marginal way
Miss Portland Diner
Tomaks, LLC.

MEMORANDUM

TO: Rick Knowland
FROM: Dan Goyette, PE – Development Review Engineer, Woodard & Curran
DATE: May 11, 2007
RE: Miss Portland Diner Minor Site Plan Review

- Engineering Plan Sheets, C-100, C-200, C-201, C-202, C-203, C-204, A-200, A-400, and A-401, dated April 24, 2007, by David D. Leasure Architectural Associates, Inc. received on May 9, 2007.

DAVID D. LEASURE - ARCHITECTURAL ASSOCIATES INC.
 1344 WASHINGTON AVENUE PORTLAND, MAINE PH. (207) 797-8661 FAX (207) 797-8533
 PROJECT NO.: 040306 PROJECT TITLE: MISS PORTLAND DINER PROJECT
 SCALE: 1" = 10'-0" SHEET TITLE: SITE PHOTOMETRIC PLAN

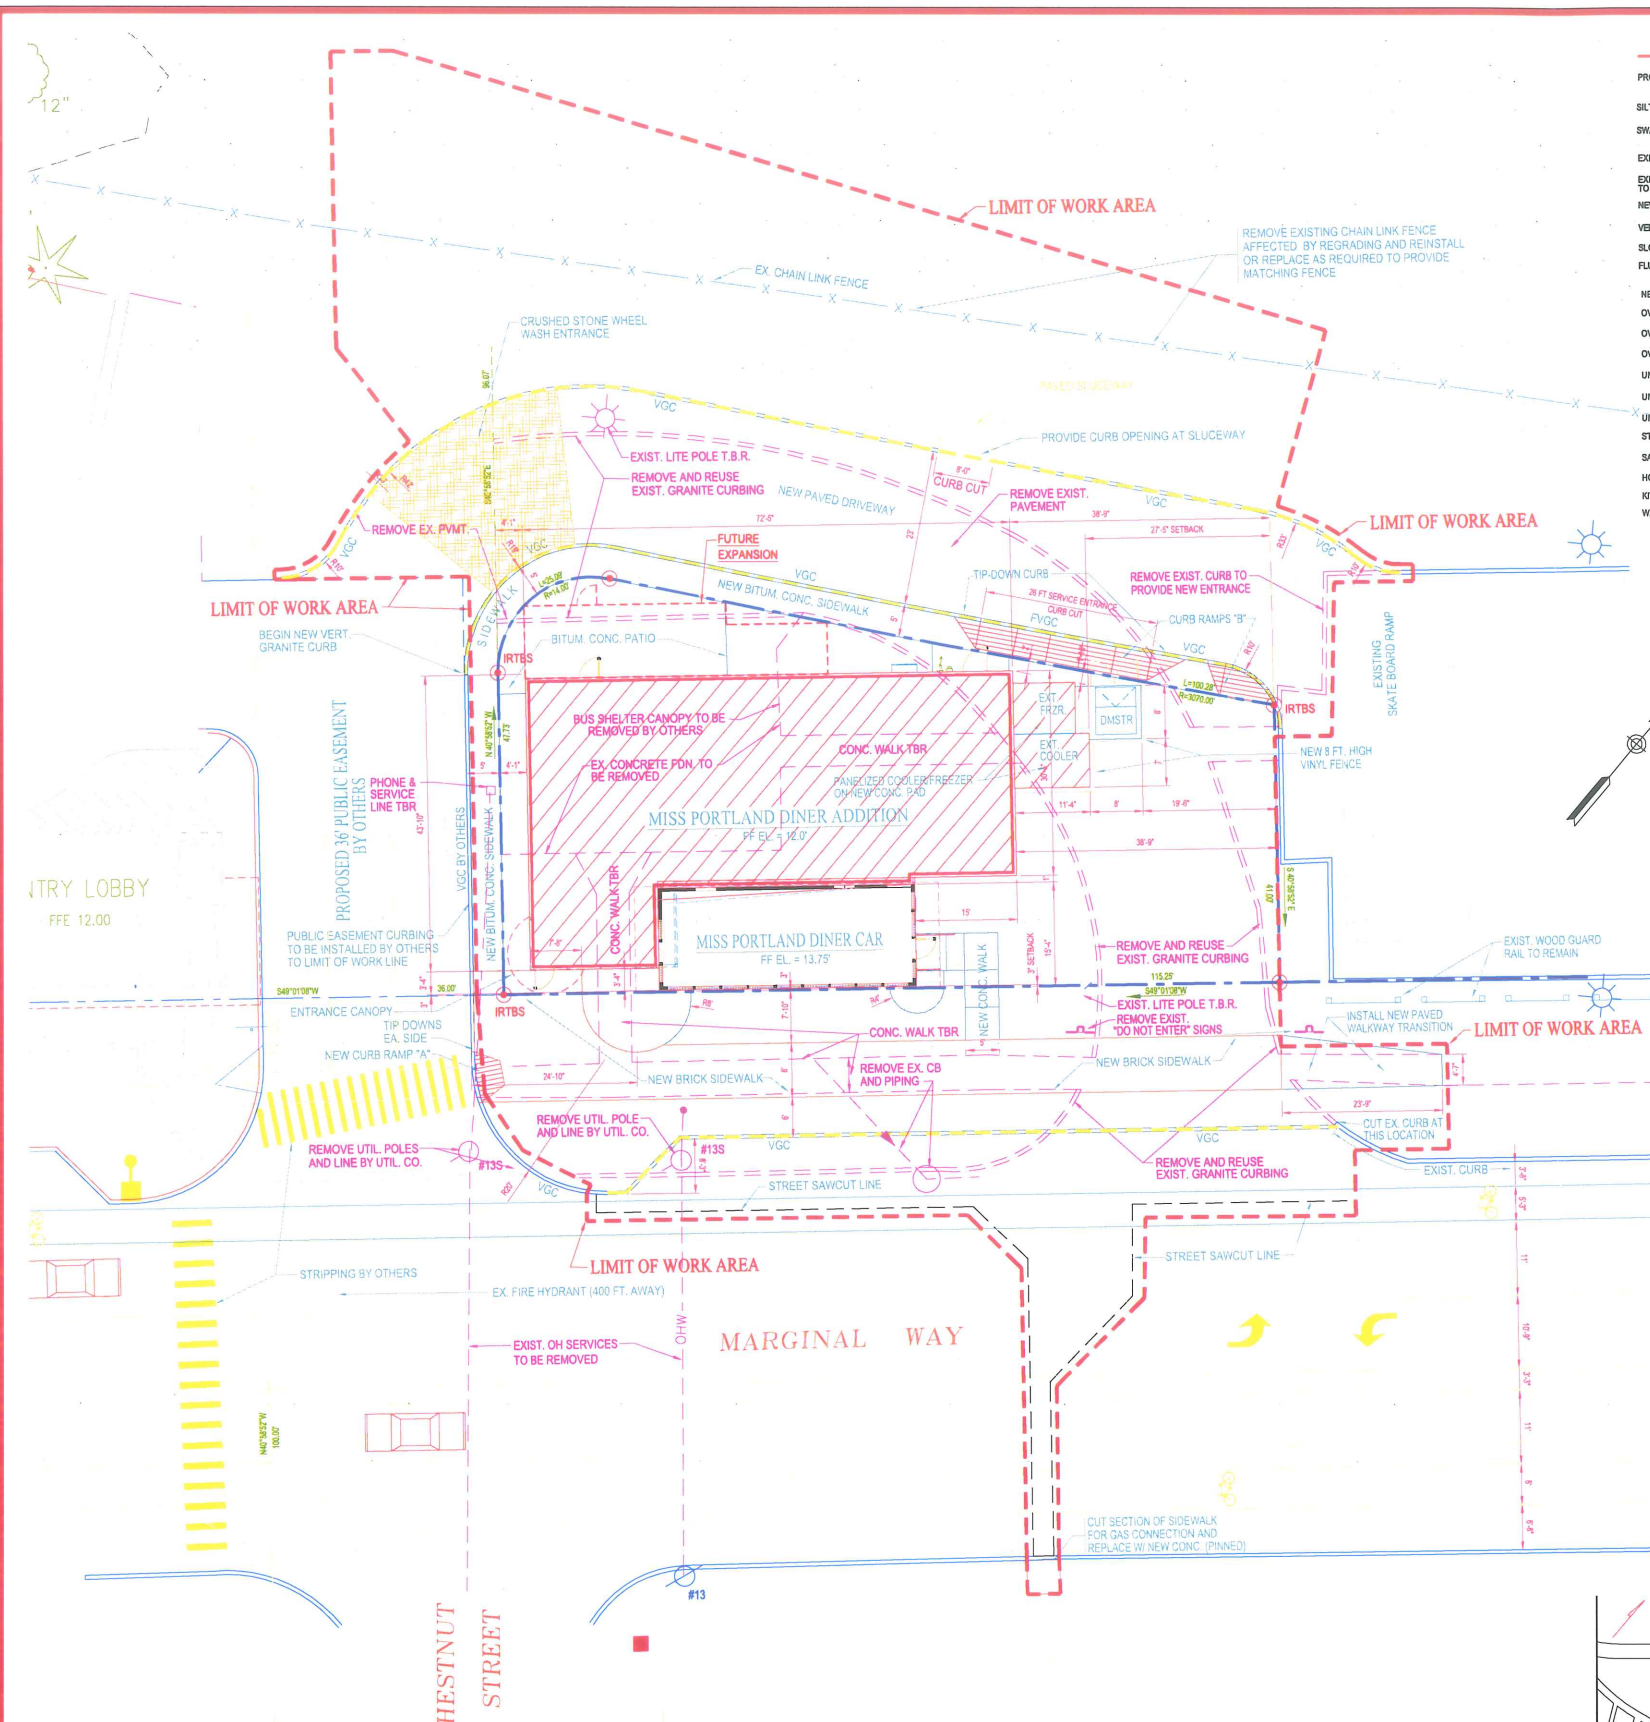
8. That the applicant shall receive approval for a City license for the landscape related improvements within the Marginal Way right-of-way.
9. Catalog cuts of the proposed light fixtures shall be submitted for review and approval. Fixtures shall have a full cut-off feature. Photometric plan shows elevated light levels along certain sections of the site. Plan shall be revised and submitted for review and approval.

DAVID D. LEASURE - ARCHITECTURAL ASSOCIATES INC.
 1344 WASHINGTON AVENUE PORTLAND, MAINE PH. (207) 797-8661 FAX (207) 797-8533
 PROJECT NO. 040306 PROJECT TITLE: MISS PORTLAND DINER PROJECT
 SCALE: 1" = 10'-0" SHEET TITLE: SITE UTILITY PLAN

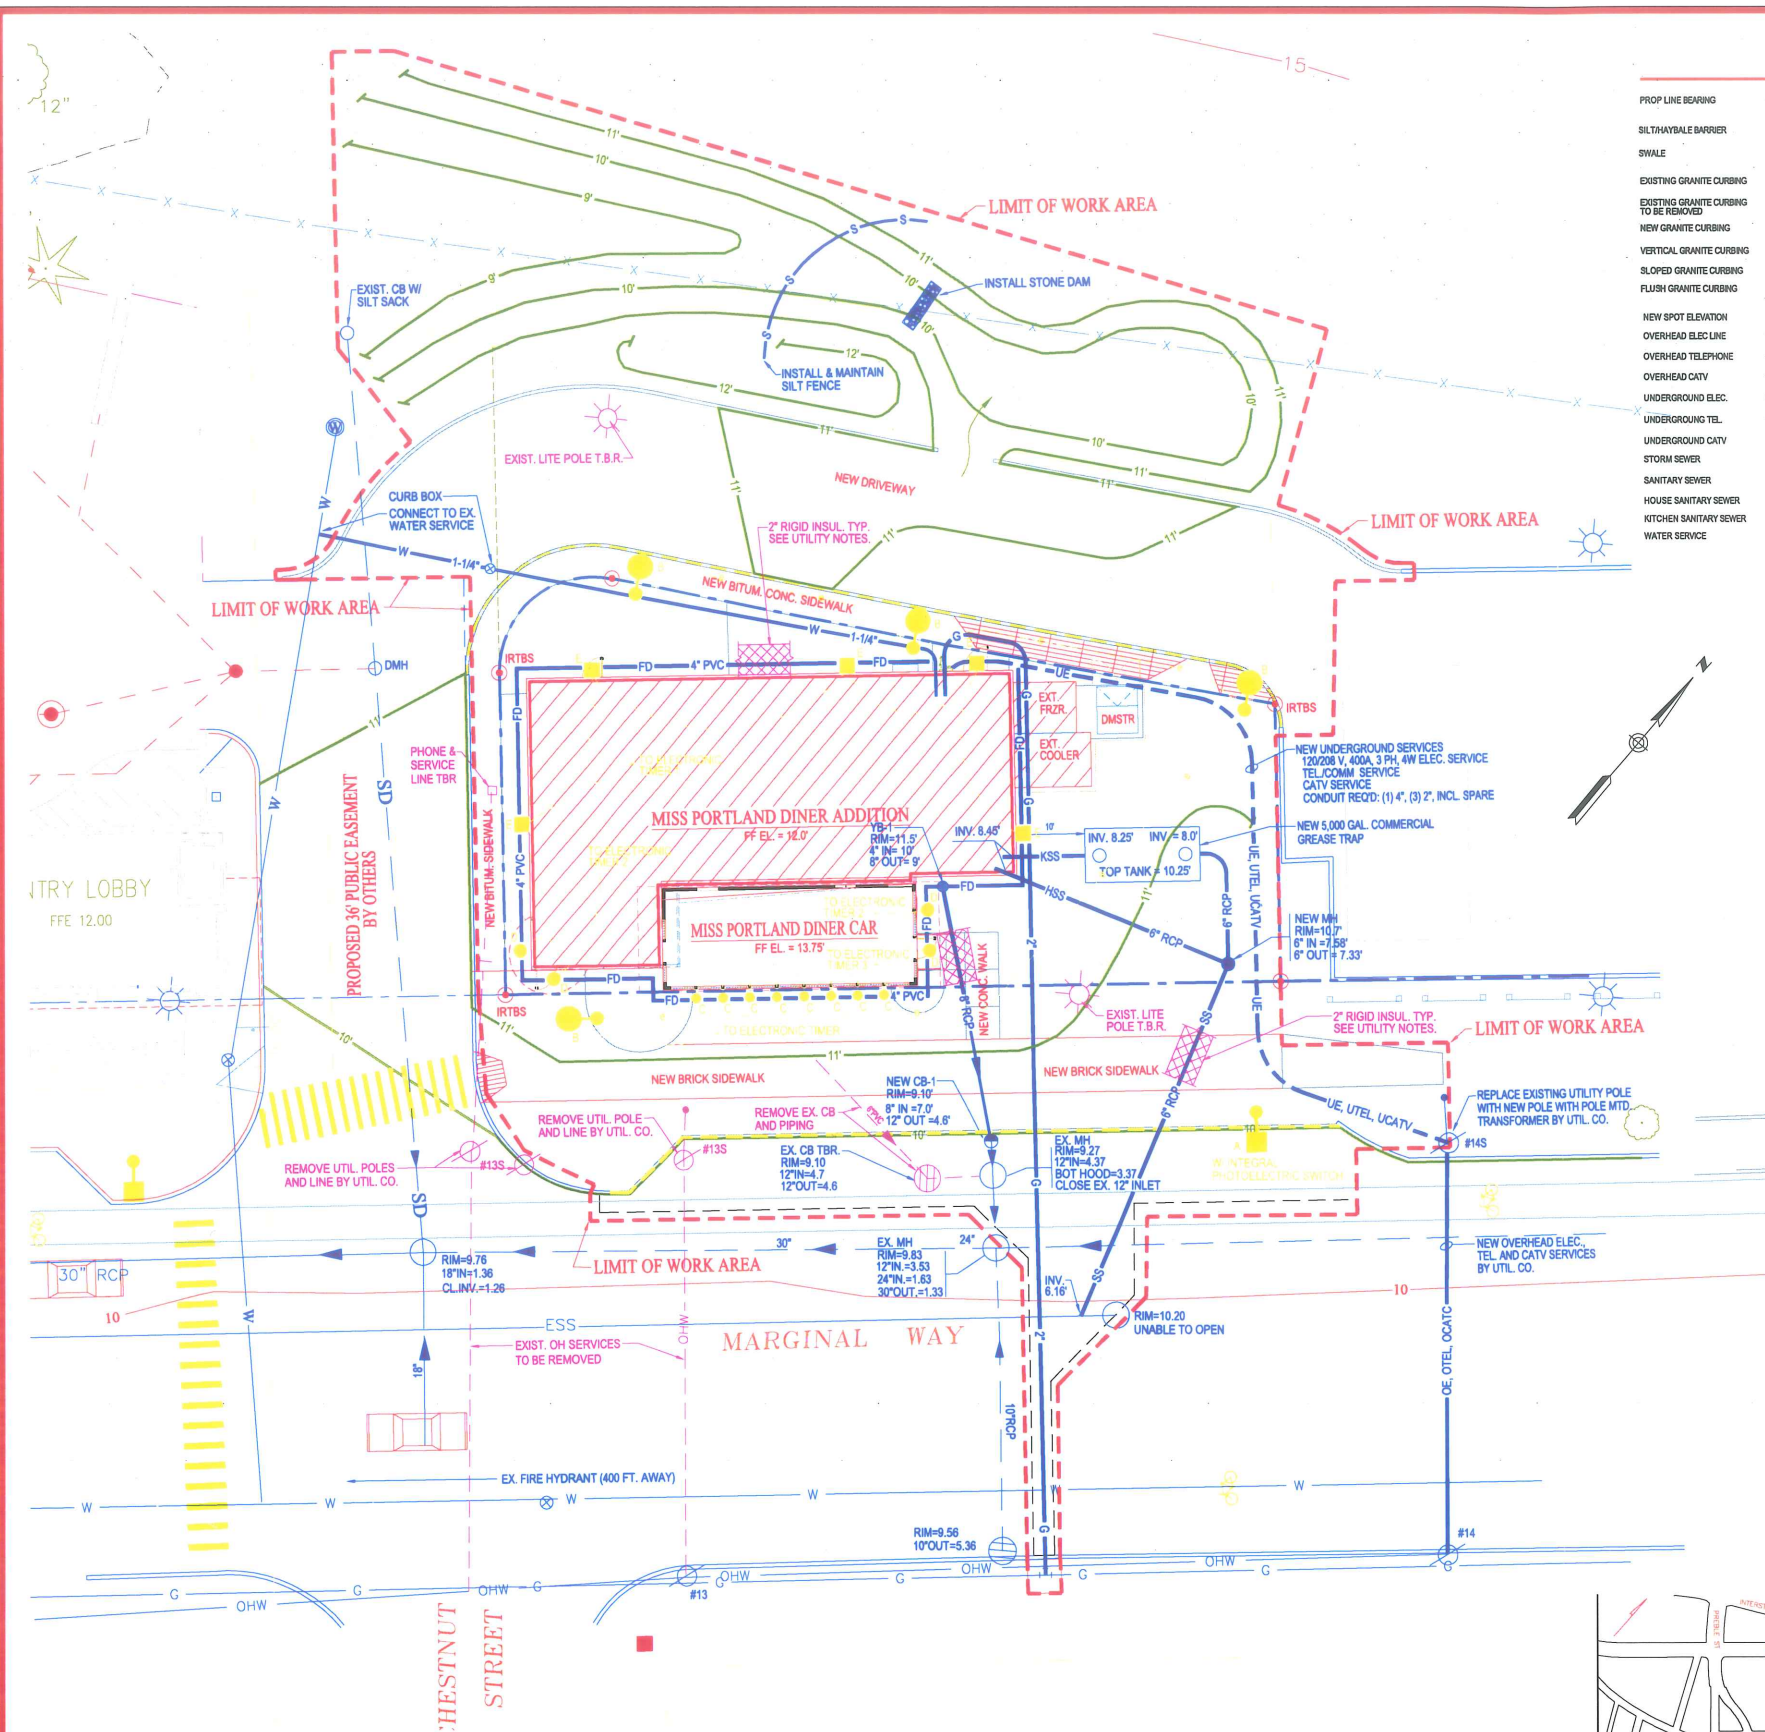
- At the rear of the building, the new light pole bases are shown to be installed directly over the new water service line.
- The applicant shows a 90 degree bend made of RCP pipe leaving the grease trap. This type of bend is not recommended and an alternate orientation of the tank is required.

- The new catch basin on Marginal Way is located directly behind an existing manhole. It is not clear if there is adequate room between the curb line and the manhole to install the new basin. The applicant may wish to show the basin offset from the manhole to insure that it can be installed properly and that the grading plan will work.

COOLER / DUMPSTER SLAB DETAIL
NOT TO SCALE

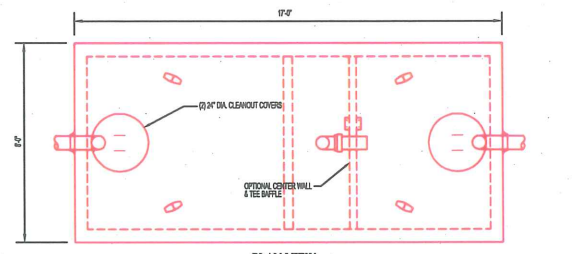
- 0 need met 3. A more appropriate screening material including a manufacturer's catalog cut for the exterior cooler and dumpster shall be submitted for Planning Staff review and approval.
